Our Ref: LM/ARU/22/08A

Date 25th January 2022

RE: Land West of Bilsham Road Yapton

Thank you for your correspondence of the 24th of January 2022, advising me of a Hybrid Application comprising of: Outline planning application for further phases of up to 110 No dwellings and associated infrastructure (with all matters reserved) and Full application for Phase 1 for 30 No residential dwellings, new access from Bilsham Road, public open space, landscaping, sustainable urban drainage and associated works. This application is a Departure from the Development Plan and is in CIL Zone and is CIL Liable as new dwellings at the above location, for which you seek advice from a crime prevention viewpoint.

Client	LANDLINK ESTATES
Project	LAND WEST OF BILSHAM ROAD, YAPTON
Title	MAISONNETTES - BINS & CYCLE STORE

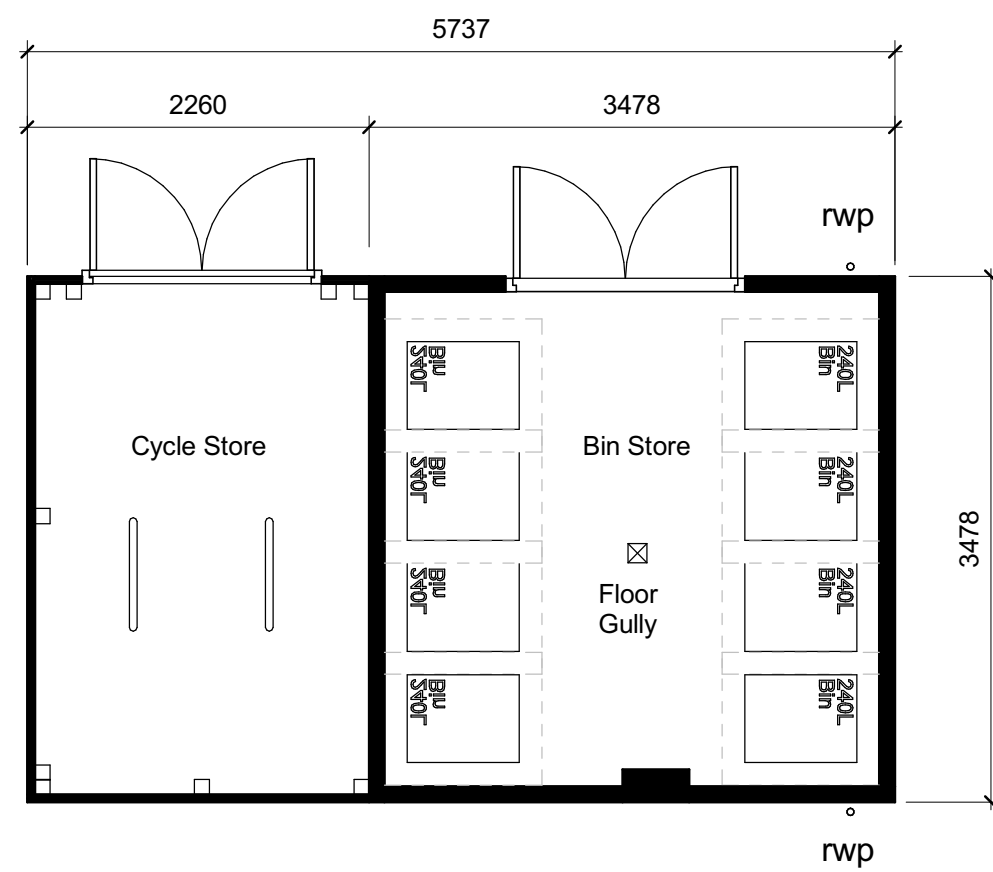
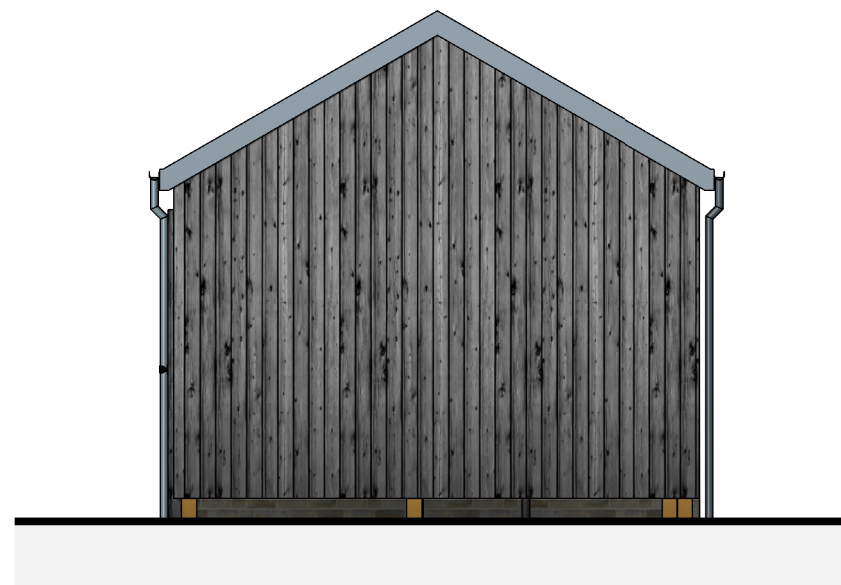
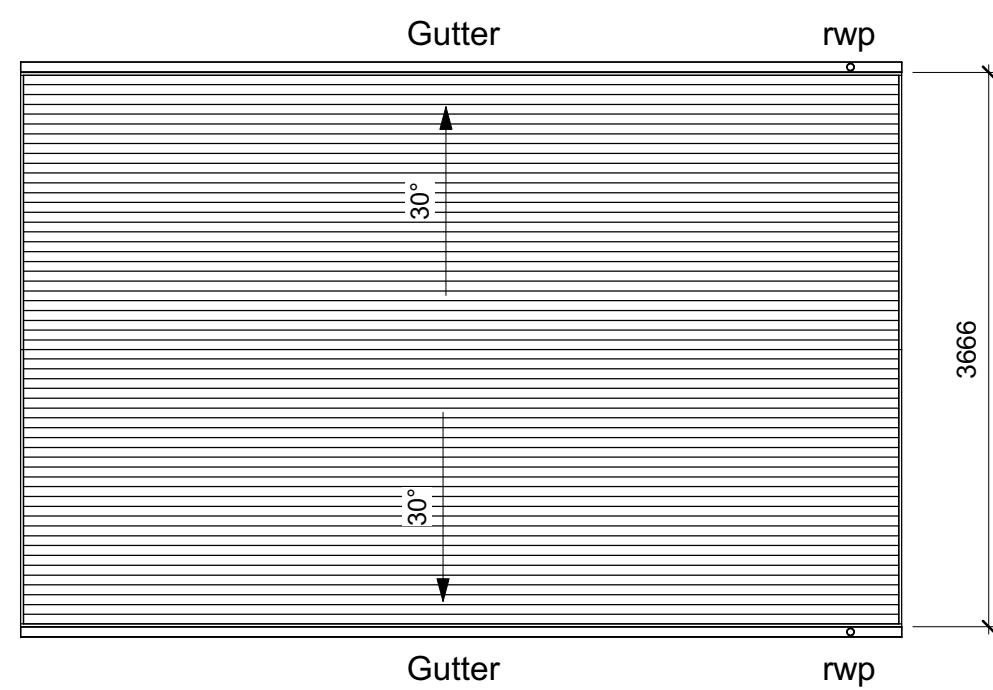
From a crime prevention perspective with regards the proposed apartment blocks within the development, it will be imperative that access control is implemented into the design and layout to ensure control of entry is for authorised persons only. Trades person or timed-release mechanisms are not permitted as they have proven to be the cause of antisocial behaviour and unlawful access to communal developments. For additional information I refer the applicant to chapter 27 of the SBD Homes Document Version 2 2019.

With regards to the siting of any bicycle stores within the development - research by the 'Design against Crime Centre' suggests that cyclists should be encouraged to lock both wheels and the crossbar to a stand rather than just the crossbar and therefore a design of cycle stand that enables this method of locking to be used is recommended. Minimum requirements for such equipment: • Galvanised steel bar construction (minimum thickness 3mm), filled with concrete; • Minimum foundation depth of 300mm with welded 'anchor bar'.
